Application no: 18/01246/F-2

Location: Warehouse Car Park And Land At Jacobs Douwe Edberts, Ruscote Avenue, Banbury.

This is a revised response following submission of a Transport Assessment in support of the application.

Transport Schedule

Appendix F - Proposed Drainage Strategy

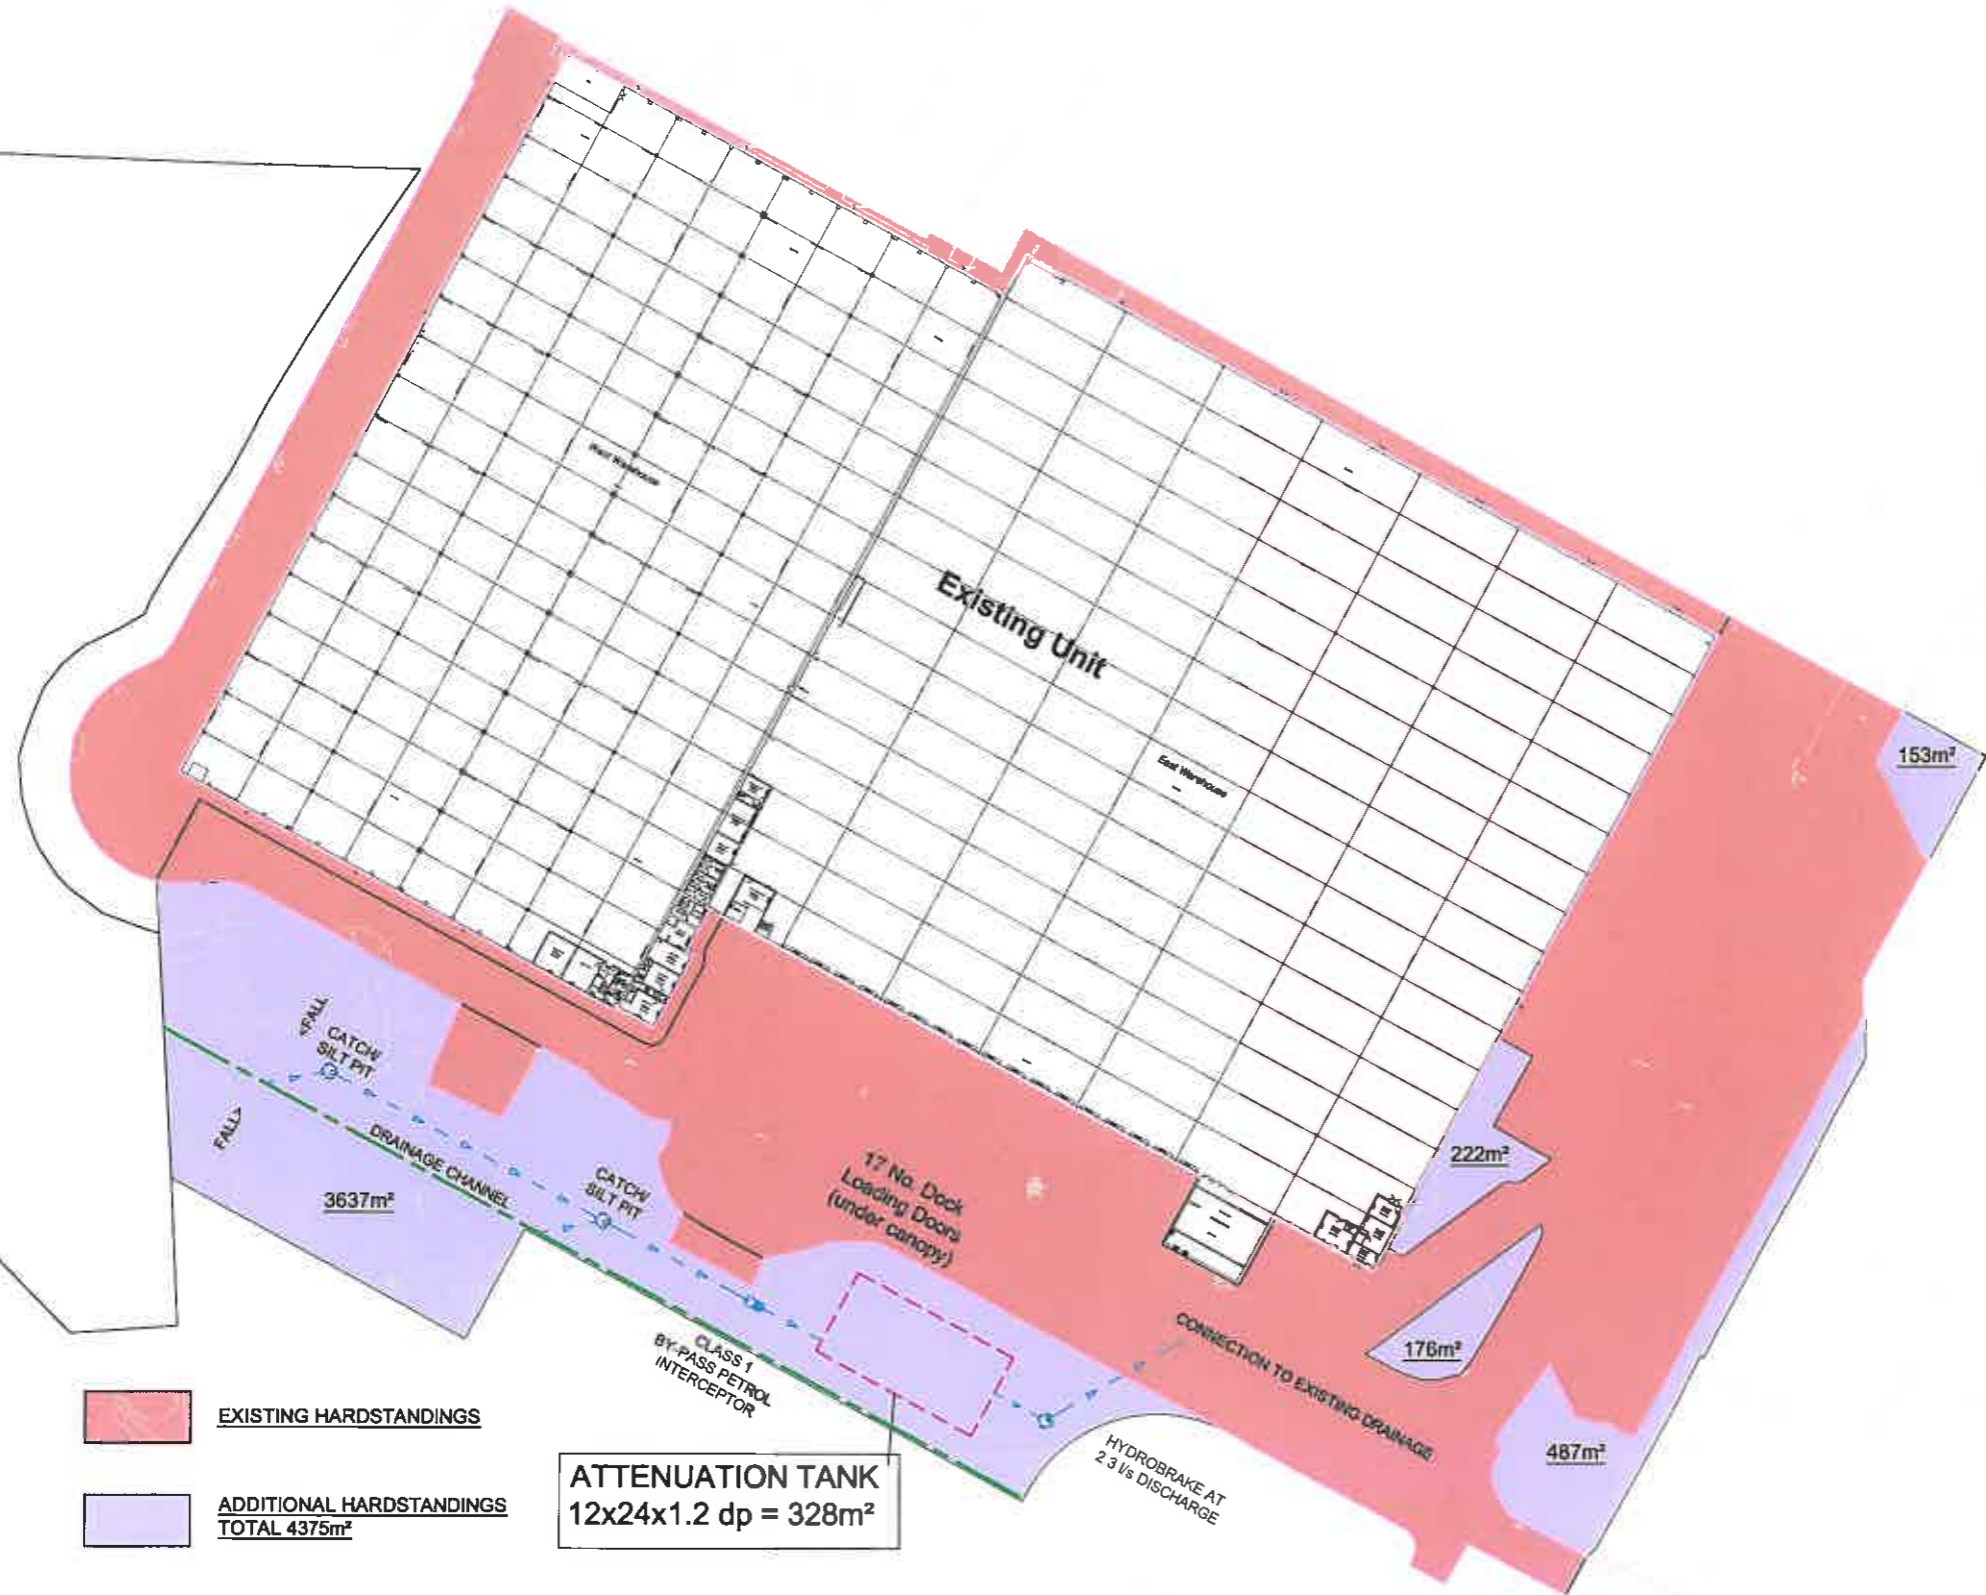
The SuDS proposals include the use of underground attenuation tank to manage surface water so that flood risks are not increased. The surface water will be restricted to outflow at 2.3 l/s in the 100-year (+CC allowance) storm event scenario by the use of a hydrobrake. Full detailed design details of the proposed SuDS system were not provided within the FRA and it is proposed to undertake a survey of the existing system on site so that levels and pipe sizes can be confirmed.

As well as the consideration of the modelled events, there should be a qualitative examination of what would happen if any part of the drainage/SuDS system fails, to demonstrate that flood water will have flow routes through the site without endangering property and where possible maintaining emergency access/egress routes. This should be supported by a flood exceedance route plan.

Access Road Realigned to South to allow two way HGV flow

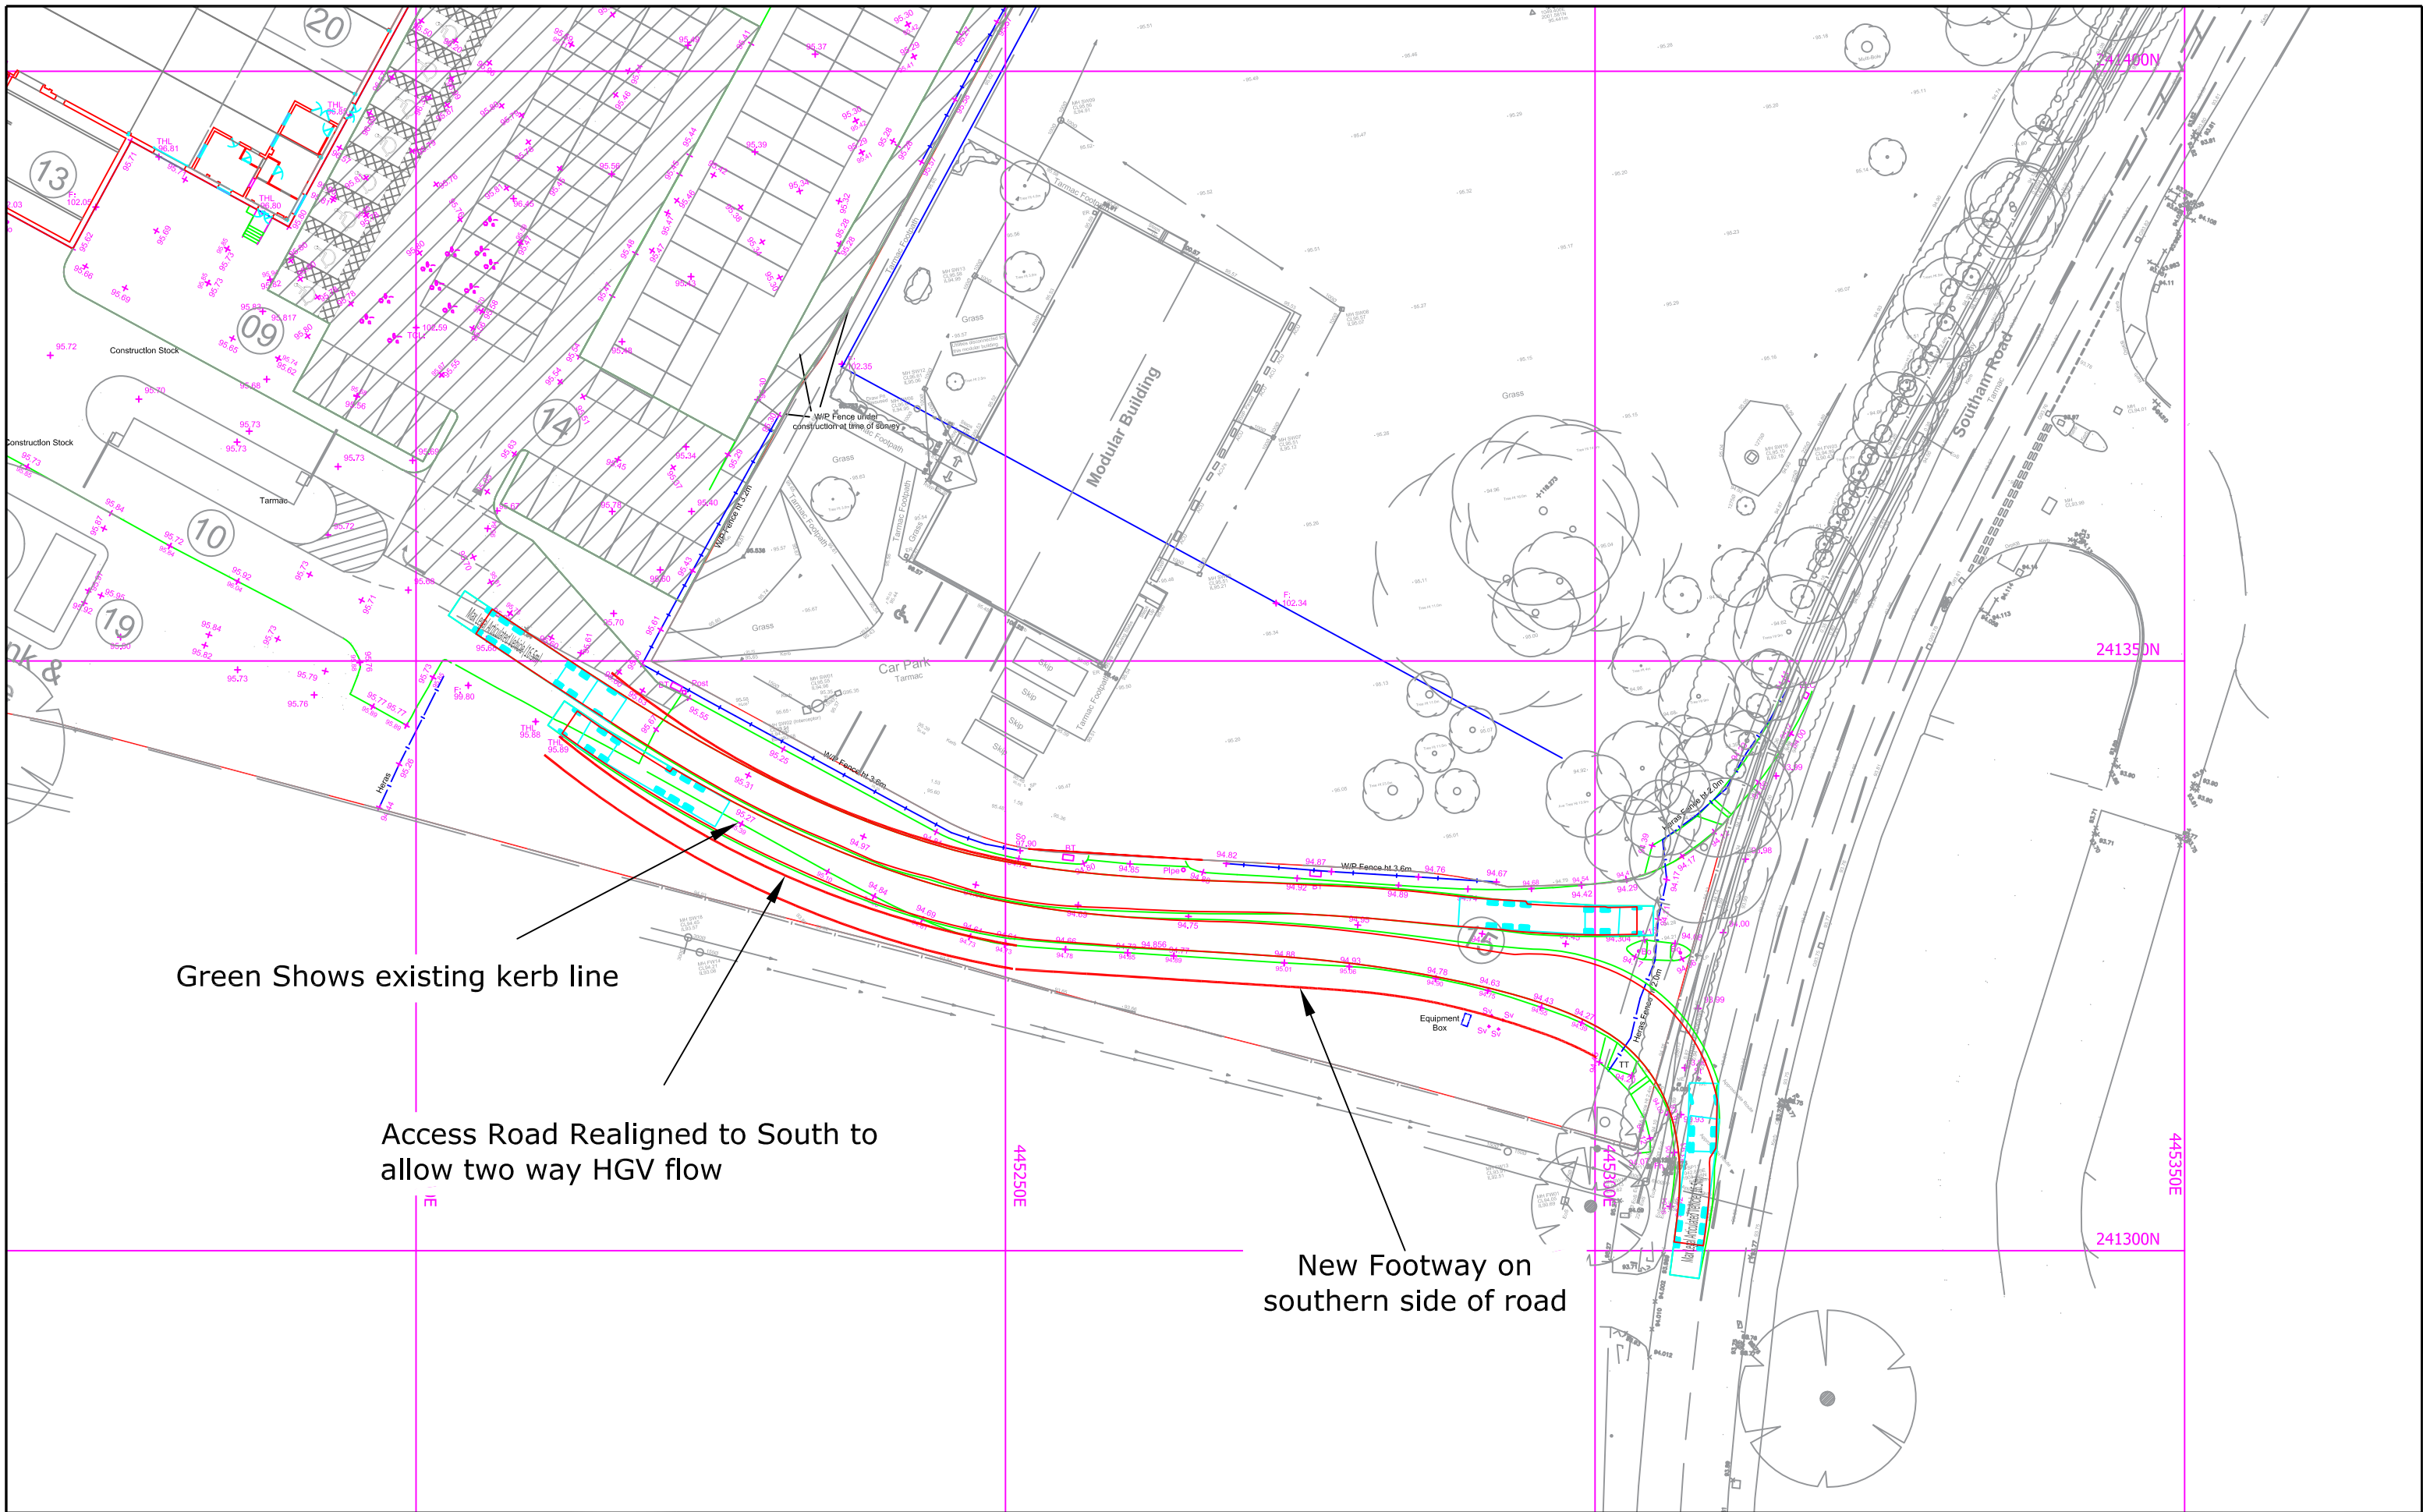
Although the site currently benefits from vehicular access from Ruscote Avenue, the application seeks to acquire new access off Southam Road utilising the recently constructed service access for Waitrose. This would render intensification of use on this service access. Swept path analysis for a 16.5m articulated vehicle has been submitted (Drwg No. 19519 – 03) which shows that the access is suitable for large vehicles.

I am not satisfied that the form of junction (site access with Southam Road) is suitable in this location on the basis of the traffic flow along Southam Road without a right turning lane. Irrespective of whether the development impact is significant on the network, I feel that with

Southam Road being only about 6.5m wide it would be safe and desirable to provide a marked right turning pocket to allow vehicles to sit while waiting for a gap in traffic without feeling pressured to make unsafe manoeuvres.

DMRB (Vol 6 Section 2, Part 6 TD42/95) clearly gives guidance in choice of major/minor priority junctions such as this, based on traffic flow and volume. The OCC count site on Southam Road has recorded nearly 15,000 AADT (2-way flow) for the past years. Fig 2/2 of DMRB (Vol 6 Section 2, Part 6 TD42/95) shows the preferred form of major/minor junction. The guidance goes on to say that *“This is based on a wide range of factors, such as traffic flow, the nature and proportions of large goods and passenger carrying vehicles, geometric and traffic delays, an initial estimate of entry and turning stream capacities, and accident costs. It should also be based on a consideration of the particular site characteristics such as development and topography”*

Site Plan (Location of Proposed Cycle and Smoking Shelter)

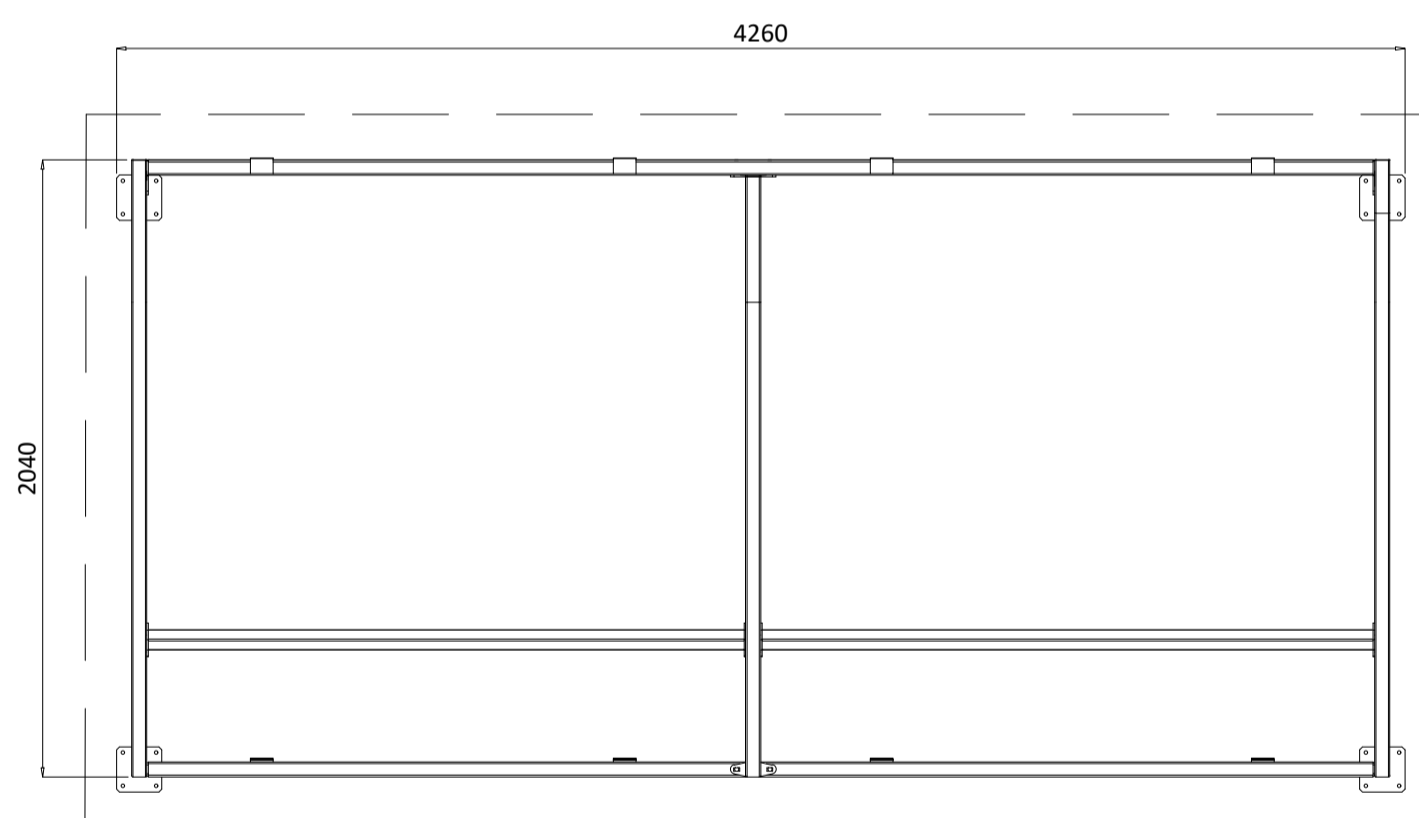
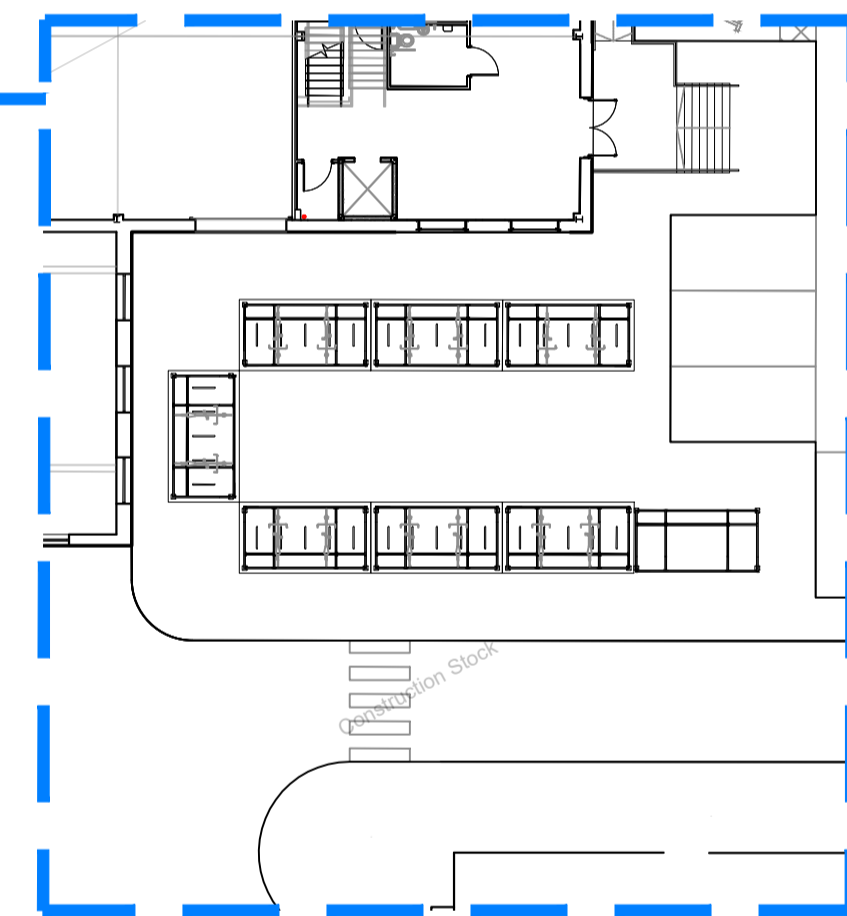
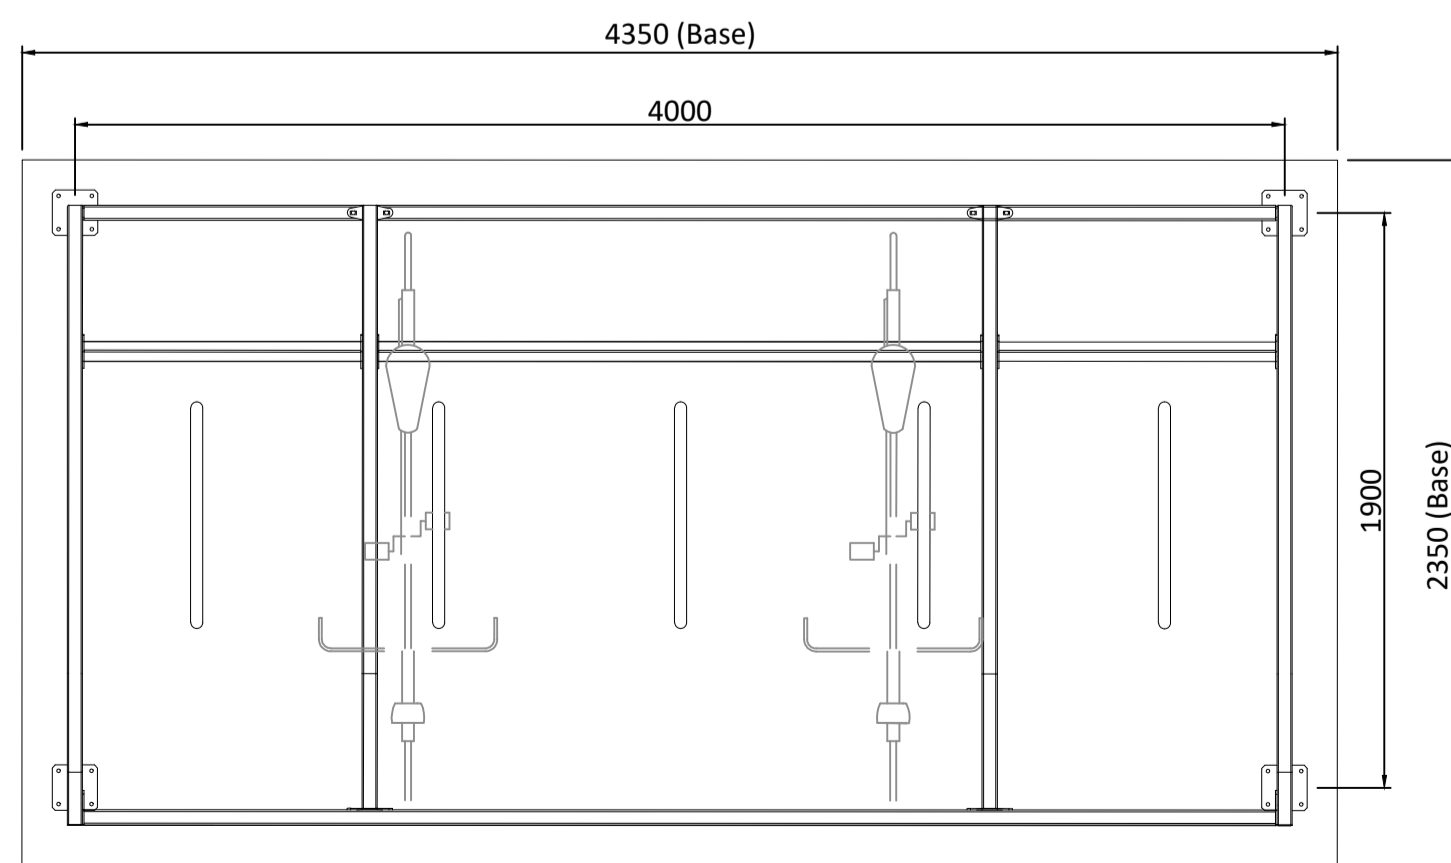
Cycle Parking – In the preapp advice from OCC, it was mentioned that with an existing footway/cycleway on Southam Road, cycling facilities will need to be extended into the site to provide for safe walking and cycling to work. Covered, secure cycle parking will need to be provided on site in accordance with OCC’s cycle parking standards.

I am left concerned by the level of provision proposed, showing only 7no. cycle shelters which does not accord to OCC minimum standards. Even taking the least conservative of the land uses in this case (B8), this would require a minimum of 19 cycle stands. Developments should be well integrated with existing or proposed transport infrastructure, including pedestrian, cycle and public transport networks, to ensure that a development is accessible by a variety of transportation modes, and should be of a scale that is in keeping with the capacity of the local highway network. (NPPF)
